From: Nolan, Chris <Chris.Nolan@lancashire.gov.uk>
Sent: 25 October 2017 13:57
To: Adam Birkett; planning
Subject: RE: D3.2017.0813 - Dale Hey Bungalow Preston Road Ribchester
Attachments: SPlanScan17102314570.pdf

Planning Application No: 3/2017/0813

Proposal: Proposed new road access and driveway to garage at rear of premises.

Location: Dale Hey Bungalow Preston Road Ribchester PR3 3XL

Dale Hey Bungalow
 Preston Road
 Ribchester
 PR3 3XL *PROPOSED NEW ACCESS AND DRIVEWAY TO GARAGE*
 DDG REF 2317 CB/RF.

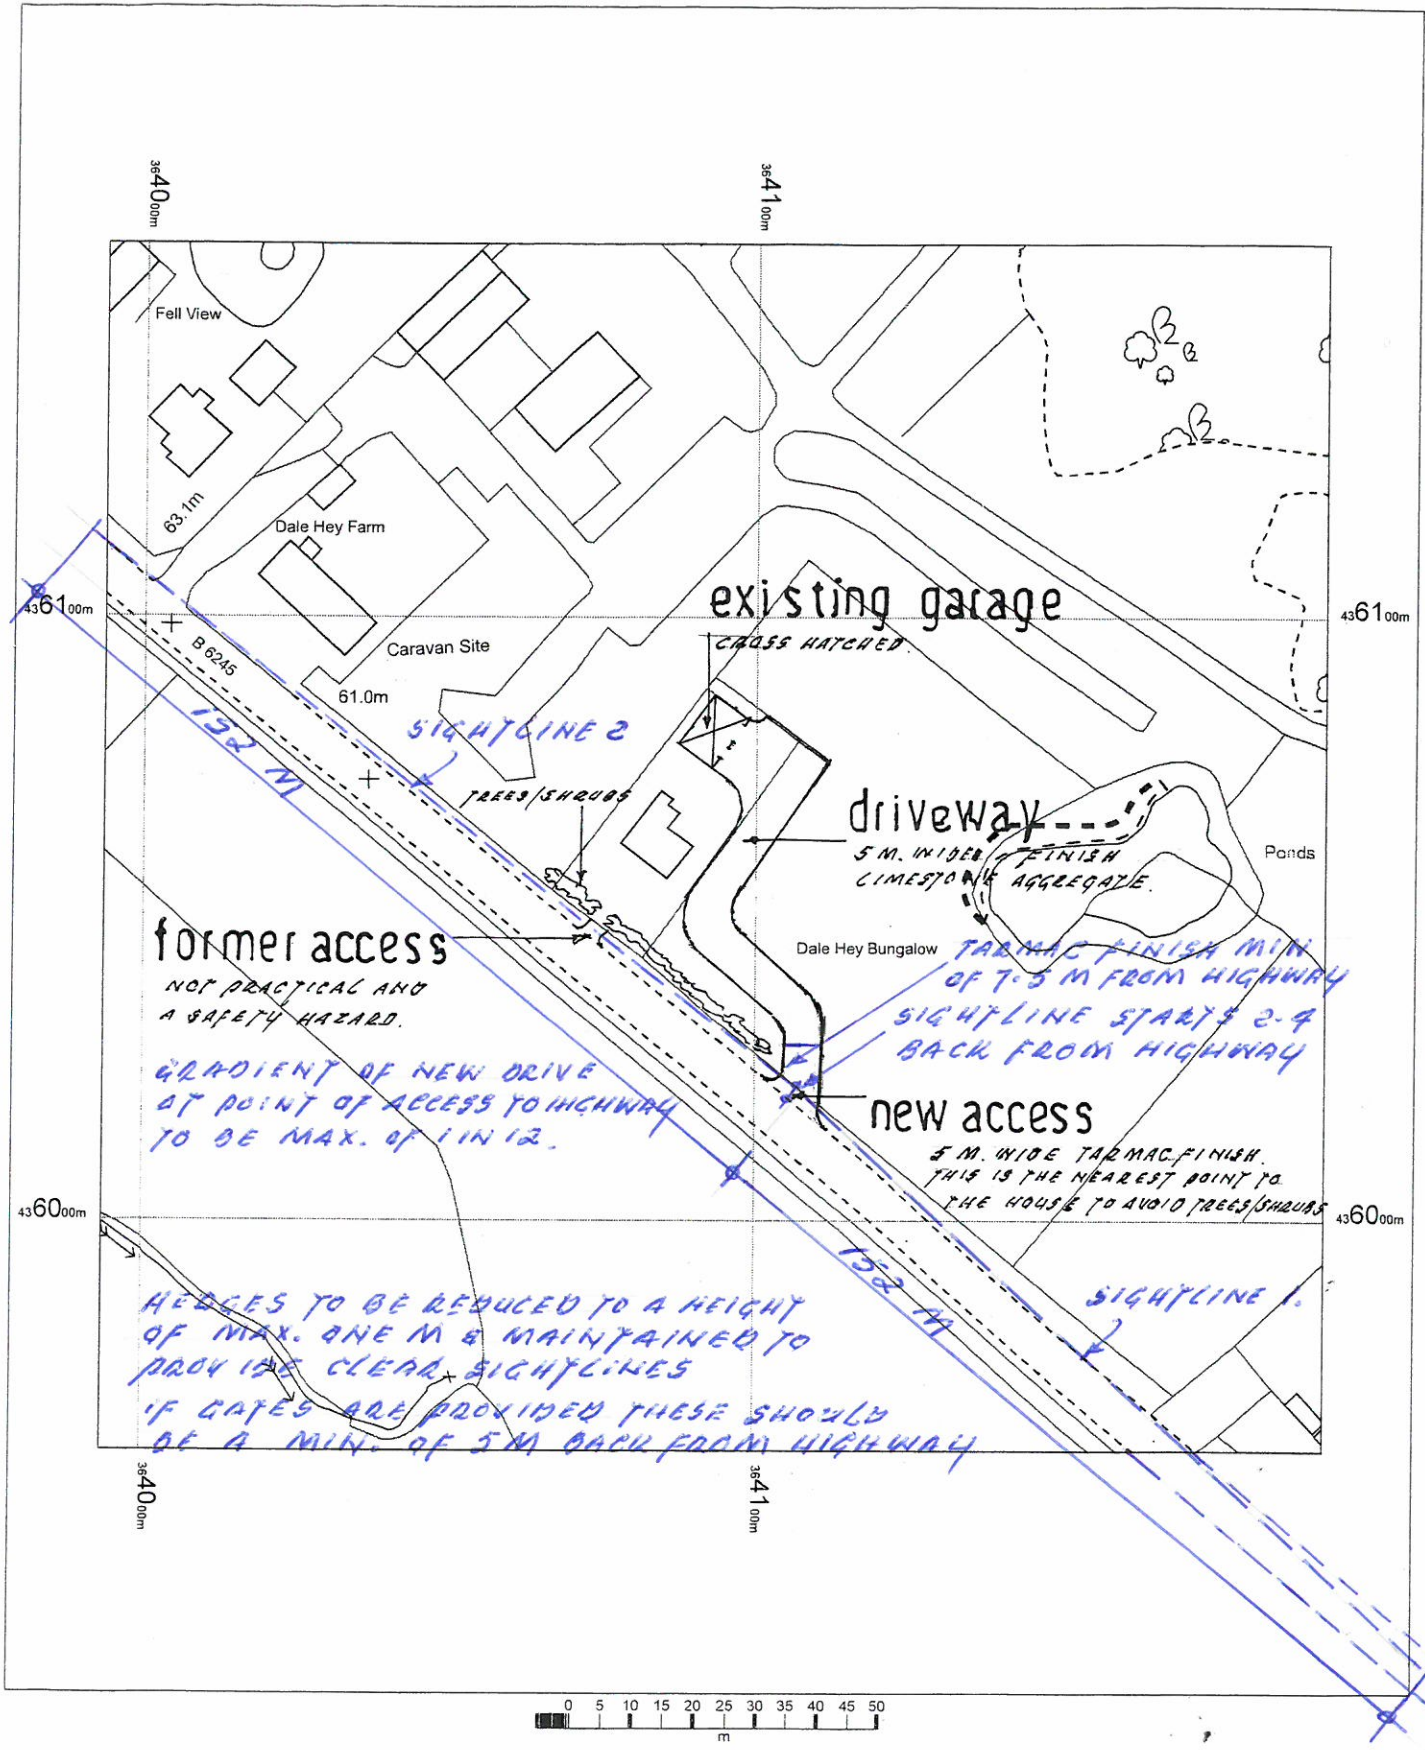
With regard to the above planning application, the amended drawings as supplied do address most of my concerns but I am still uneasy about the angle of the new drive to Preston Road. It can be appreciated that the alignment is very good if the vehicle is approaching from Ribchester or leaving in that same direction.

My concern is that the left turn into the drive is particularly acute and therefore difficult to make. I feel that this could be addressed if the bell mouth at the gate could be made a little wider so that the turn to the gate could be a 90° when turning left into the drive.

I feel that subject to my earlier comments being taken into account and if a drawing with wider bell mouth could be submitted then my concerns would have been addressed.
